REVISION RESPONSE LETTER

**RE: Claremont Business Park 2 Filing 1, Lot 7
Site Development Plan
File Number PPR2030**

DATE: January 29, 2021

1 of 12
 SITE PLAN

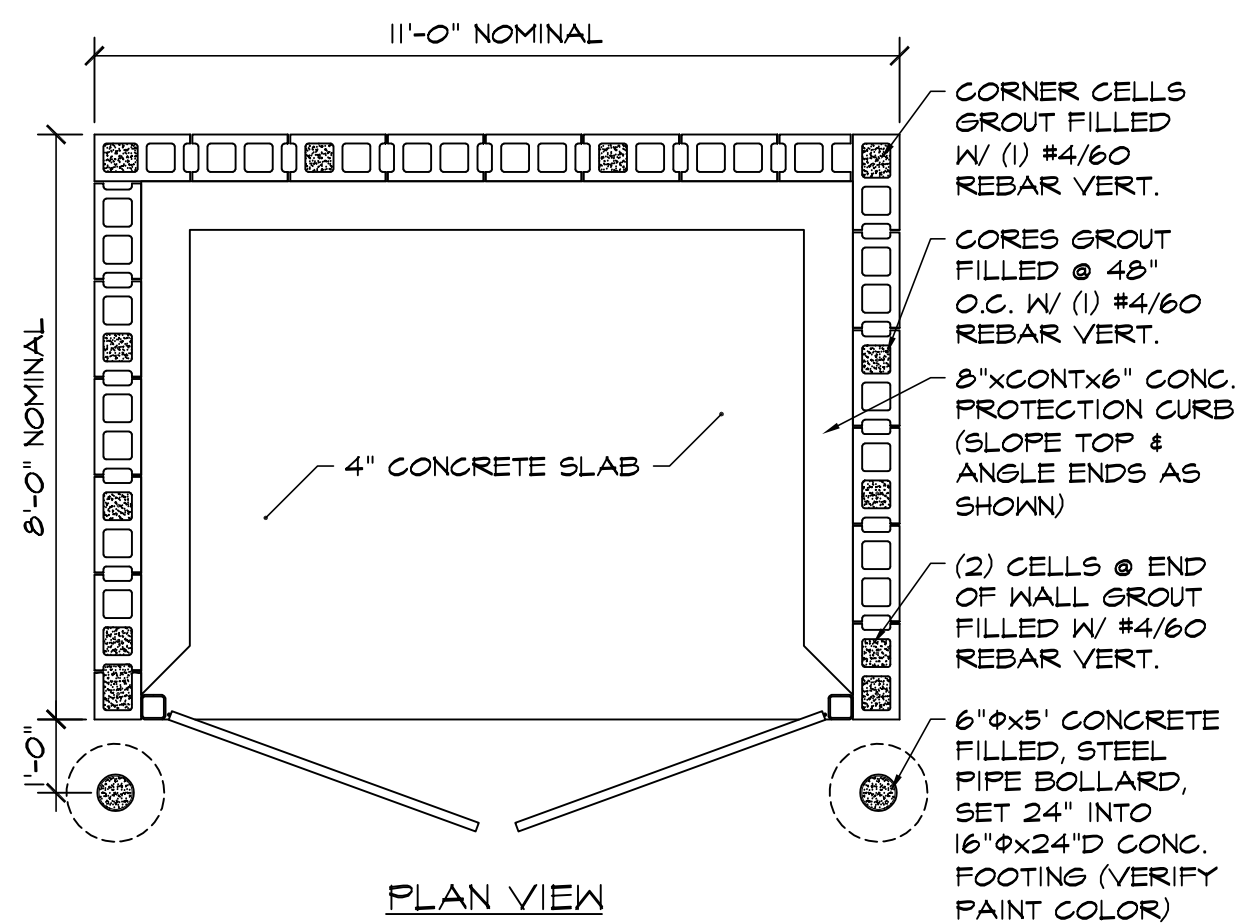
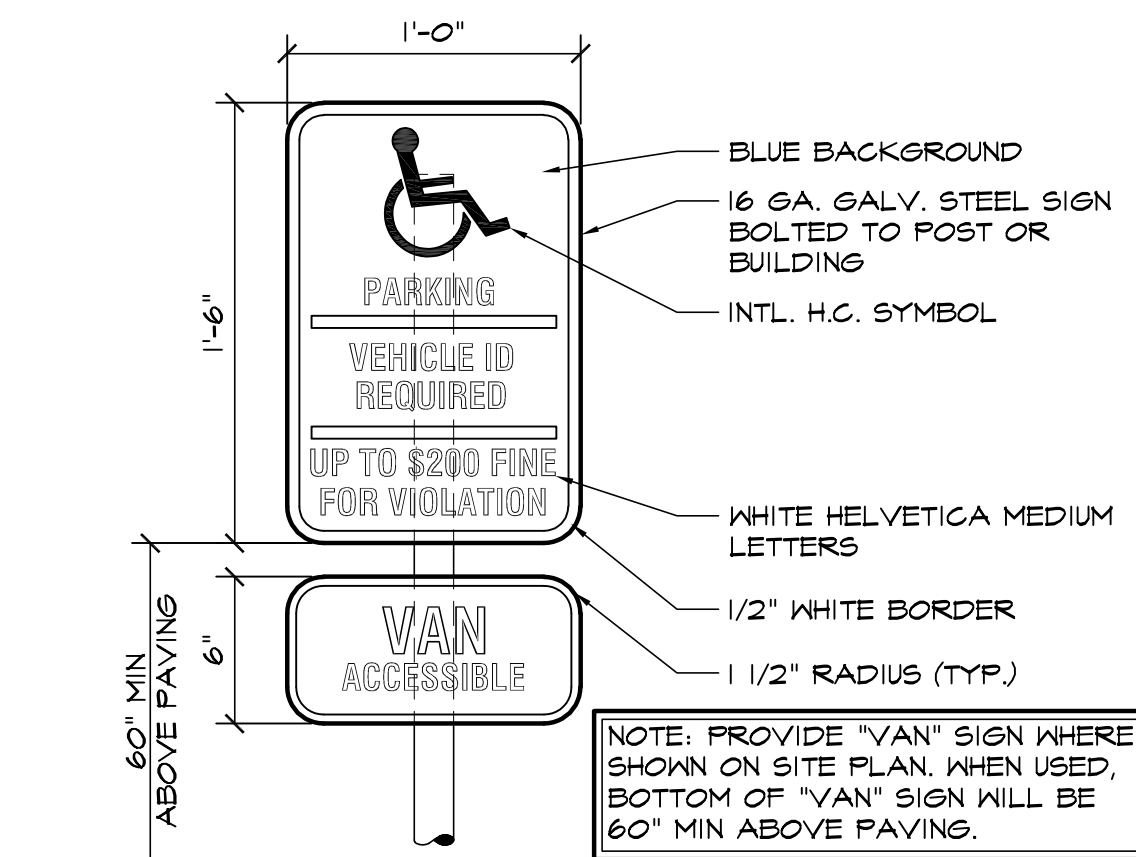
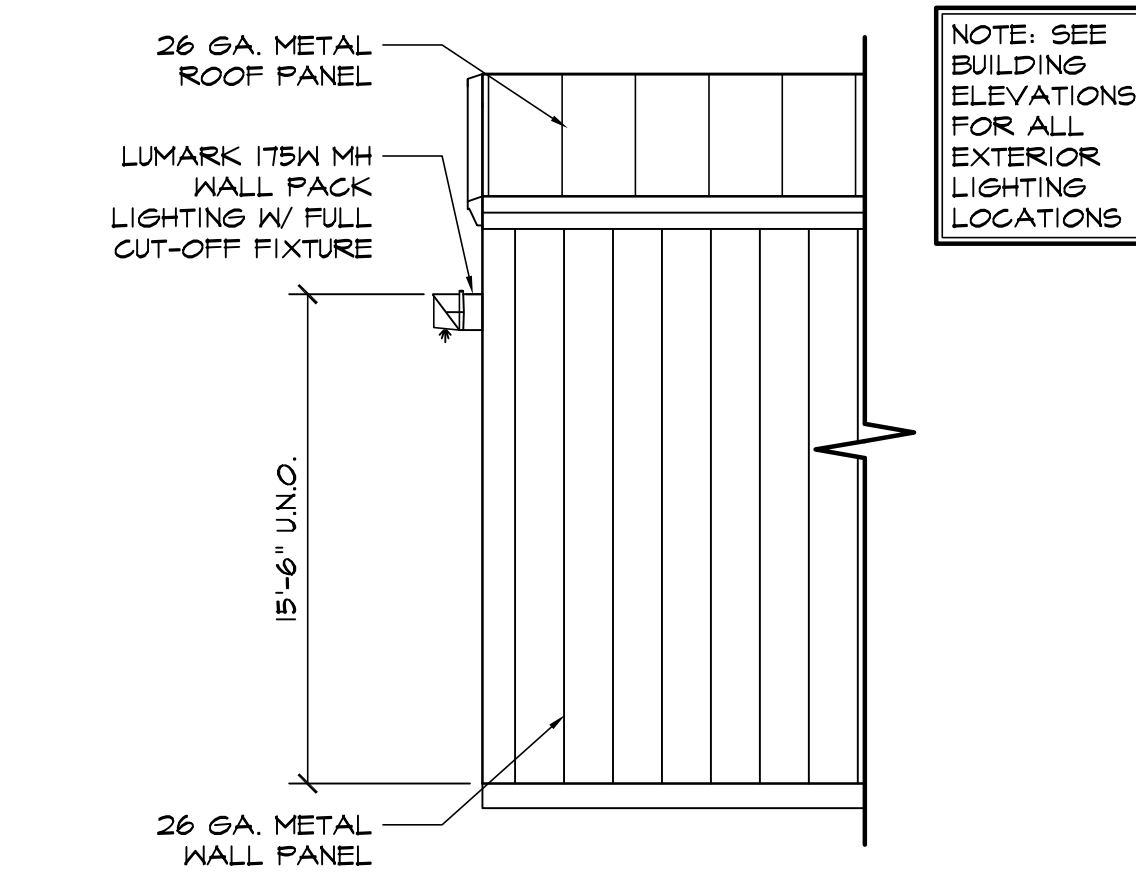
3. Access Aisle must be located on passenger side of parking spaces. Revise with access aisle on passenger side. **Per ICC a117.1-2009, 502.4.1: "Access aisles shall adjoin an accessible route. Two parking spaces shall be permitted to share a common access aisle. Access aisles shall not overlap with the vehicular way. Parking spaces shall be permitted to have access aisles placed on either side of the car or van parking space. Van parking spaces that are angled shall have access aisles located on the passenger side of the parking space." Our parking is not angled, so our design is good as shown. No changes made from this comment.**

1 of 12  
SITE PLAN

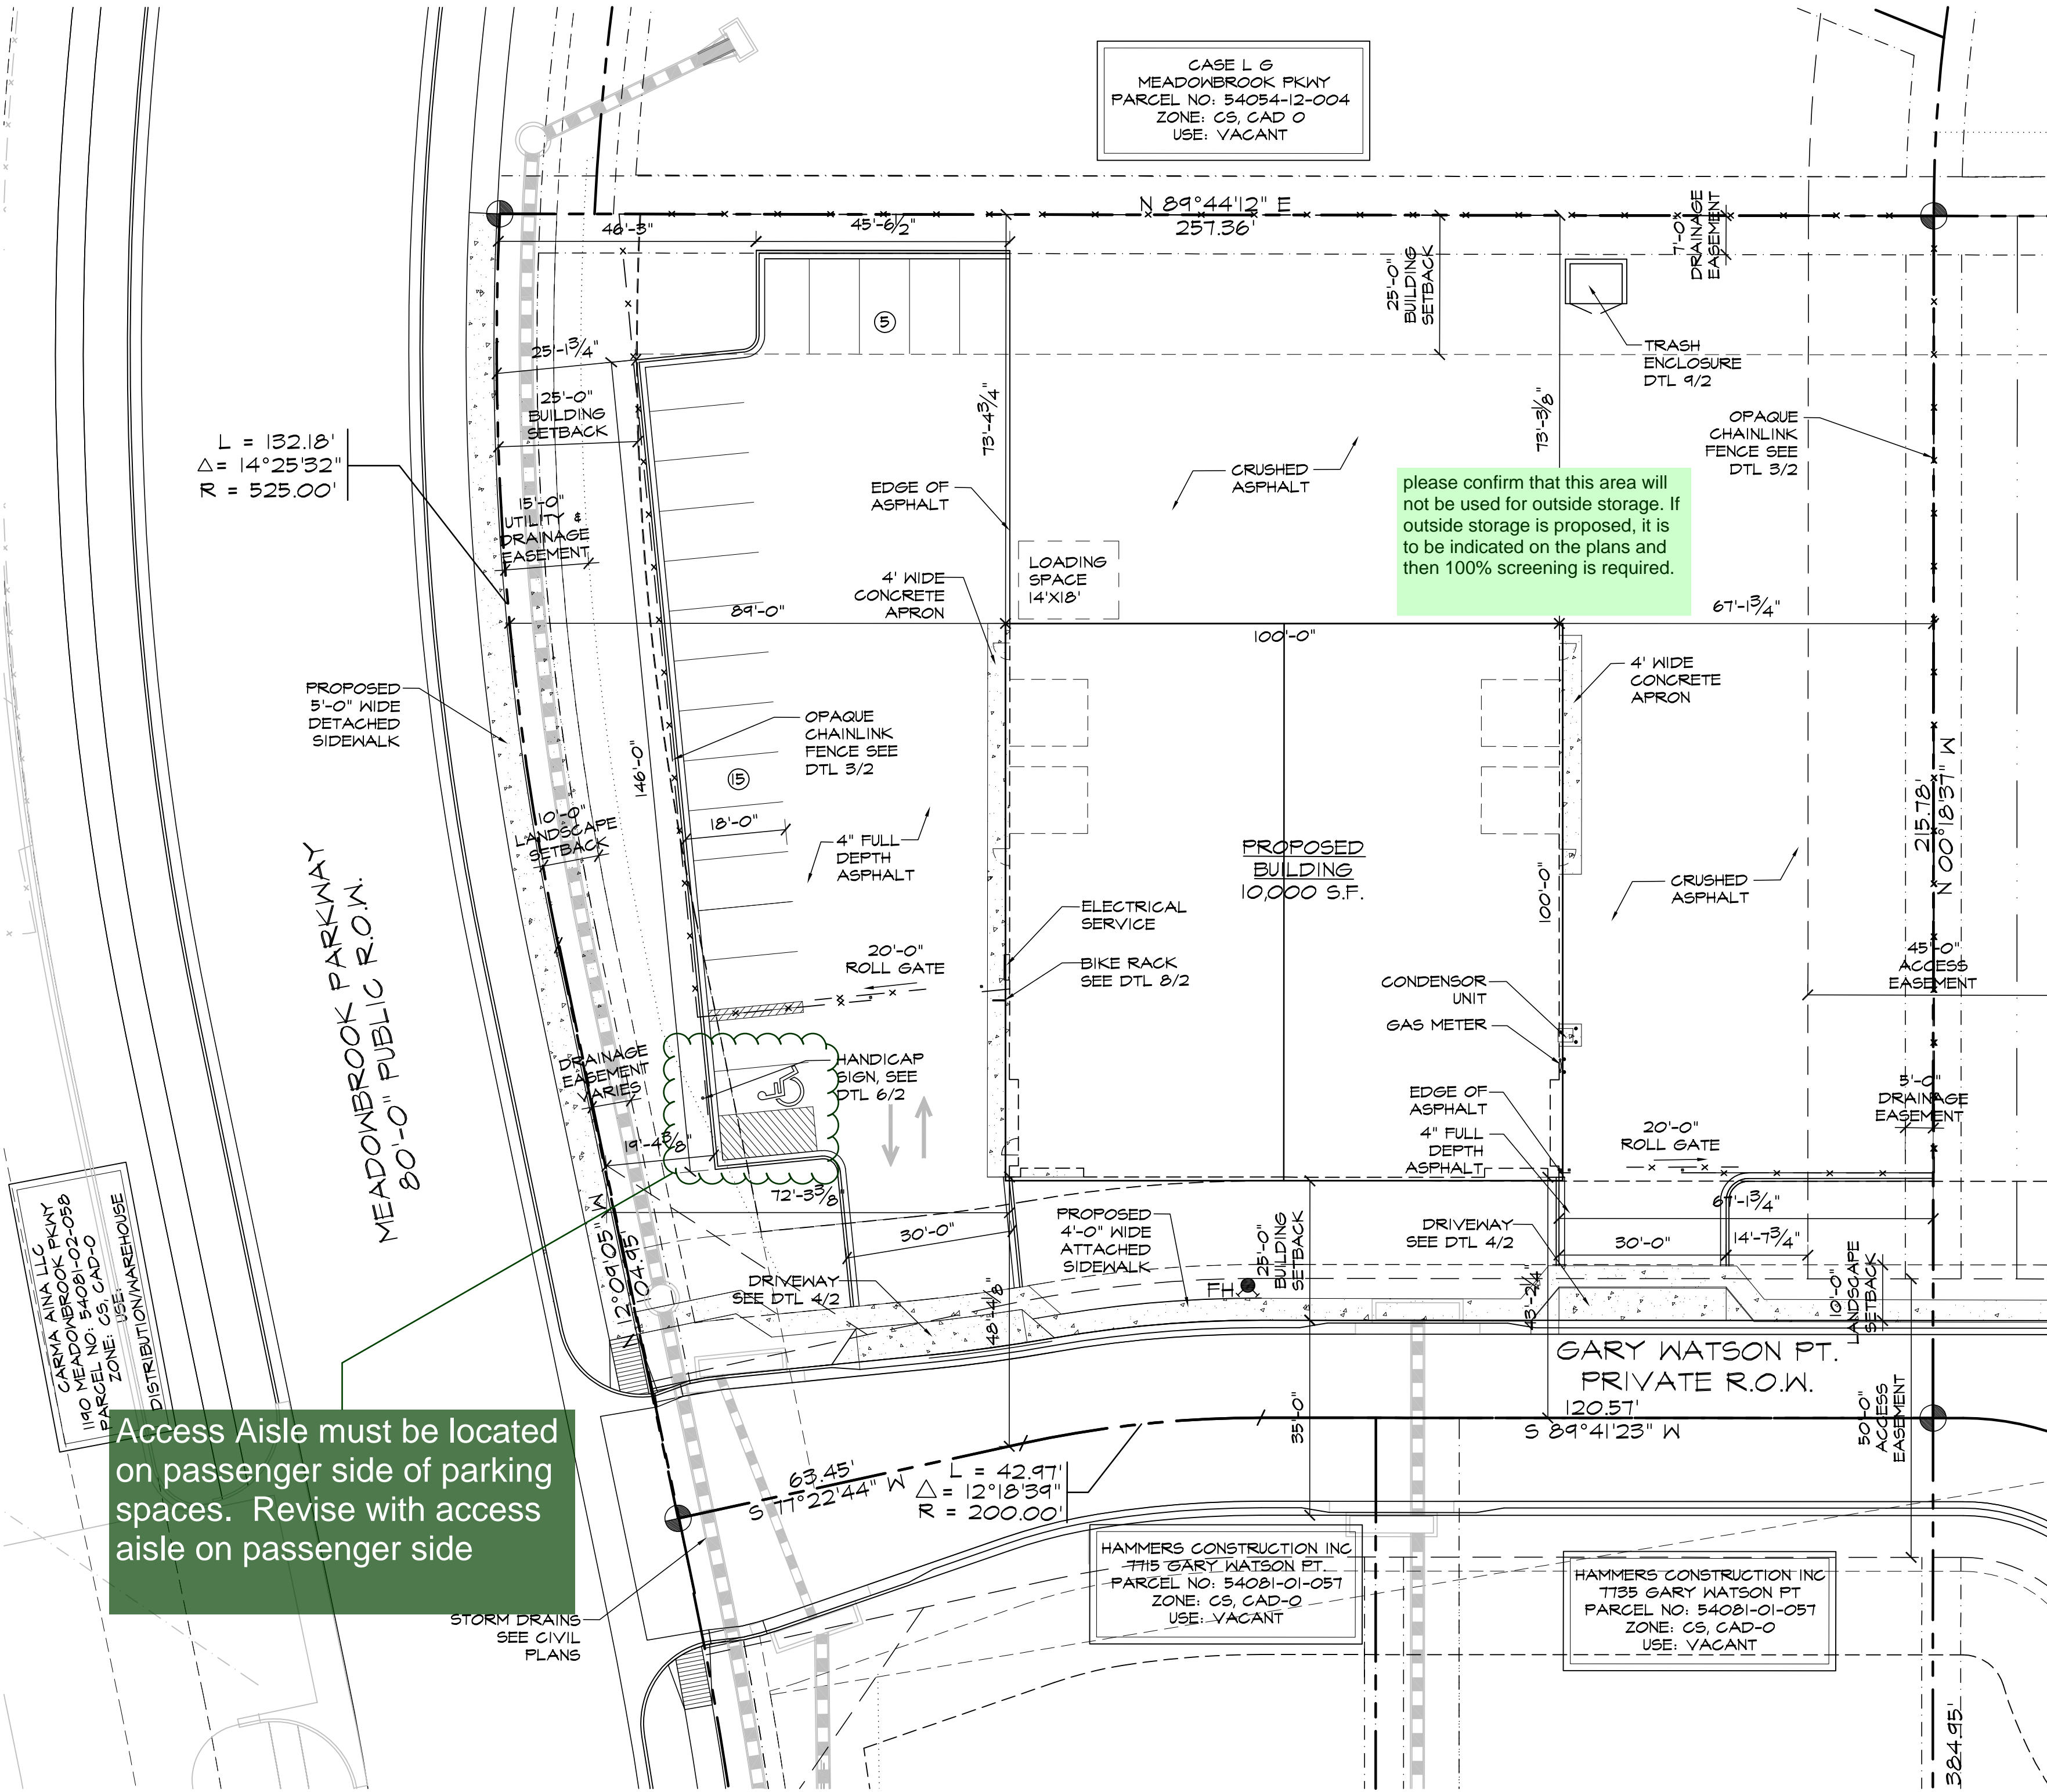
1. Please add ADA route. **Added.**
2. Please confirm that this area will not be used for outside storage. If outside storage is proposed. It is to be indicated on the plans and then 100% screening is required. **No outside storage is being requested with this submittal. If storage will be needed in the future, the owner will need to follow screening requirements per EPC zoning code.**
